Norfolk Vanguard Offshore Wind Farm

Applicant's Response to Request for Information

Applicant: Norfolk Vanguard Limited
Document Reference: ExA; WQ; 11.D10.1

Date: 28 February 2020

TITLE  
B1149 TRAFFIC MANAGEMENT

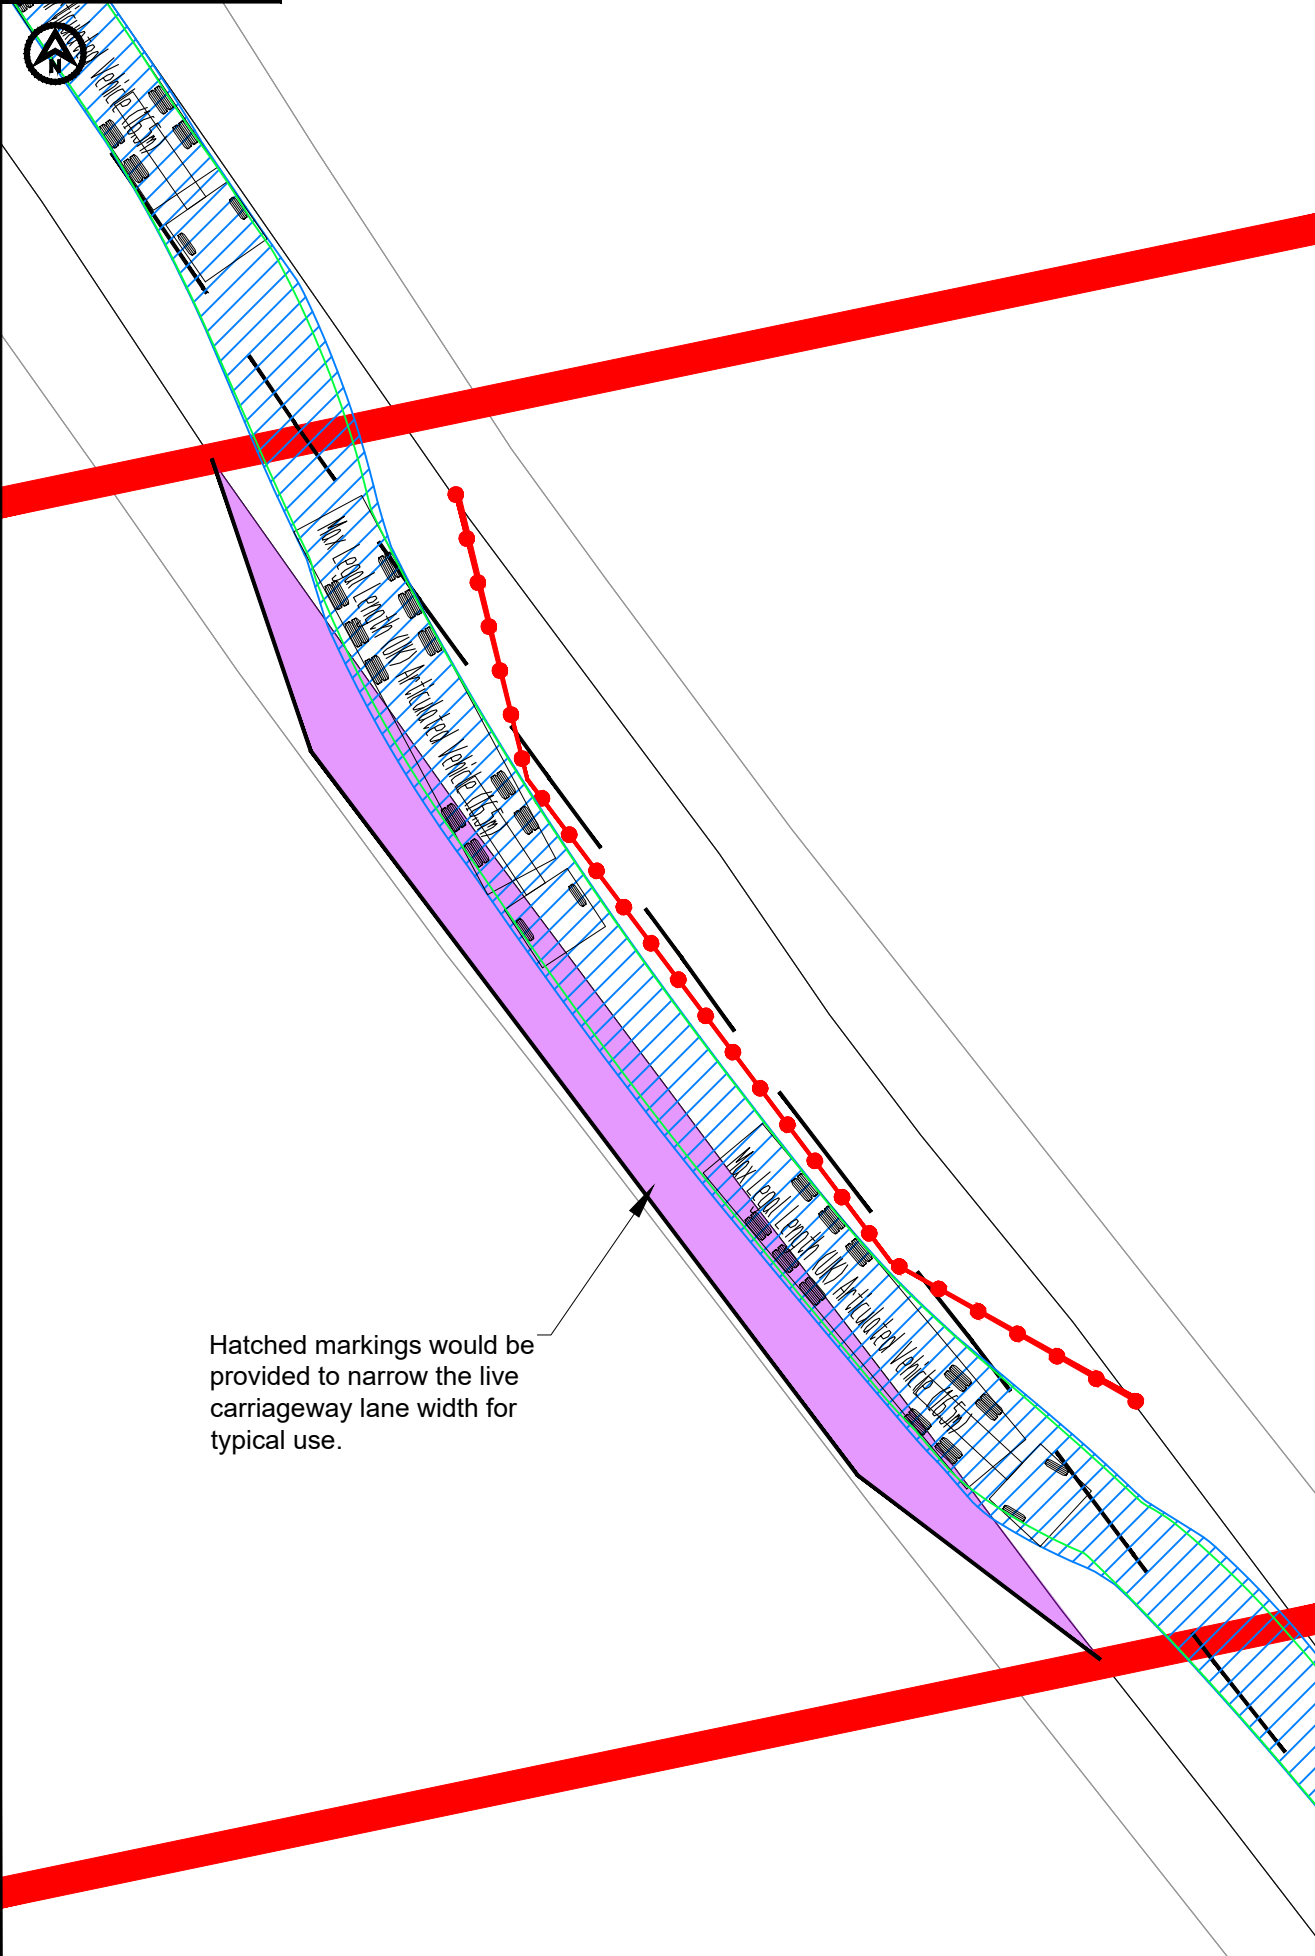
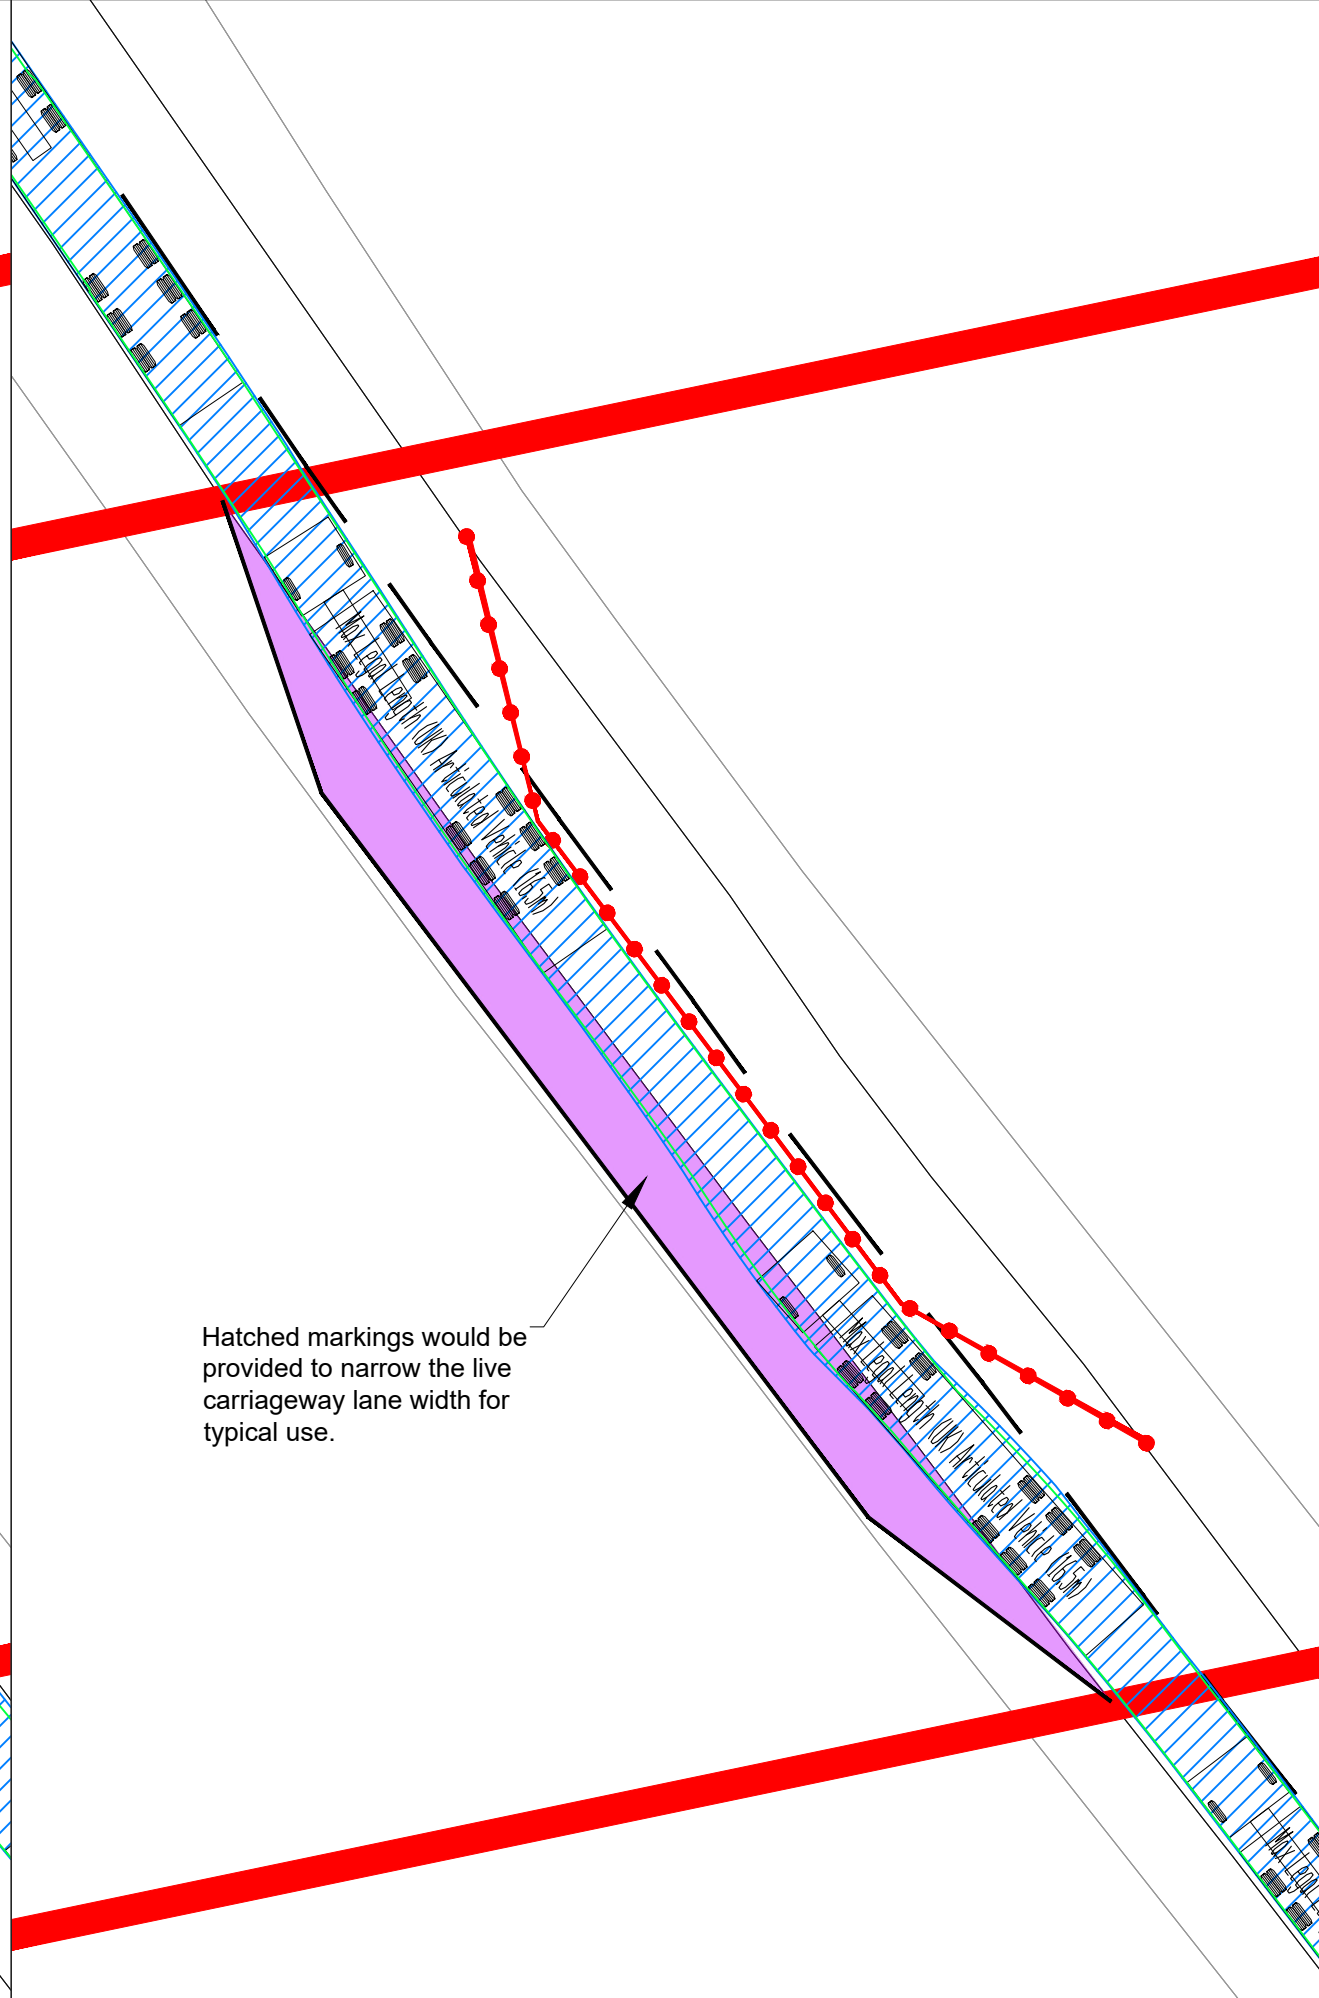
Para no.	Request for Information	Applicant's Response
20	The Secretary of State is aware that there was consideration during the Examination of the extent of the requirements for trenchless crossing to be utilised in a number of locations along the onshore export cable route. In particular, the Secretary of State notes that at the end of the Examination, there was disagreement between the Applicant and North Norfolk District Councils and Norfolk County Council about whether two particular sections of the local road network – along the B1149 and on Colby Road (Church Road), north of Banningham – should be added to the list of trenchless crossings as set out in Requirement 16 of the Applicant's proposed development consent order as submitted to the Examination for Deadline 9.	<p>B1149 (Norfolk County Council)</p> <p>The outstanding matters between the Applicant and Norfolk County Council for the crossing of the B1149, at the close of the Norfolk Vanguard examination, related to safety concerns of the proposed traffic management measures to accommodate an open cut solution for crossing the B1149, as proposed by the Applicant. In the final position statement between the Applicant and Norfolk County Council submitted to the examination at Deadline 9 (ExA; AS; 10.D9.7), Norfolk County Council retained these safety concerns as the requested swept path drawings presented a 0.5m distance of separation (between the construction works and the live traffic) whereas for traffic in proximity to deep excavations a minimum safe working distance of 1.2m should be applied (in accordance with Chapter 8 of the Traffic Signs Manual, DfT, 2009).</p>

Para no.	Request for Information	Applicant's Response
		<p>A revised open cut trench roadworks design was discussed with Norfolk County Council at meetings held on 4 November 2019 and 17th January 2020. The updated design incorporates a separation distance of 1.5m (amply allowing for the required 1.2m safe working distance) and can also accommodate Hornsea Project Three cumulative traffic (including Abnormal Loads), entirely within the current Norfolk Vanguard Order limits. During the meeting held between the Applicant and Norfolk County Council on the 15th January 2020, the Council confirmed that with this updated information of the working distances there was now no technical reason to object to the proposed open cut trenching method proposed across the B1149.</p> <p>A copy of the updated layout for the traffic management measures is included as Appendix ExA; WQ; 11.D10.1.App1.</p> <p>The introduction of a trenchless crossing in this location would introduce a potentially significant noise impact to the nearest residential property and extend the construction programme for this crossing from 1-2 weeks to 9-10 weeks. In addition, the Applicant has addressed the issues raised by Norfolk County Council to reach a position where the council has no technical reason to object to the proposed crossing method. However, should the SoS be minded to include a trenchless crossing of the B1149, the Applicant has undertaken an environmental assessment of this potential change to the previously assessed working methodology, which is included as an appendix to this response (refer to Appendix ExA; WQ; 11.D10.1.App2). The assessment identifies that trenchless crossings require the flexibility to extend into the evening and night time due to the continuous nature of those activities, and in the event of evening or night time working there is the potential for significant construction noise impacts to occur at the nearest residential property. Accordingly, construction noise mitigation would be required; this would be captured within the Construction Noise Management Plan submitted with the final Code of Construction Practice, secured under DCO Requirement 20.</p>
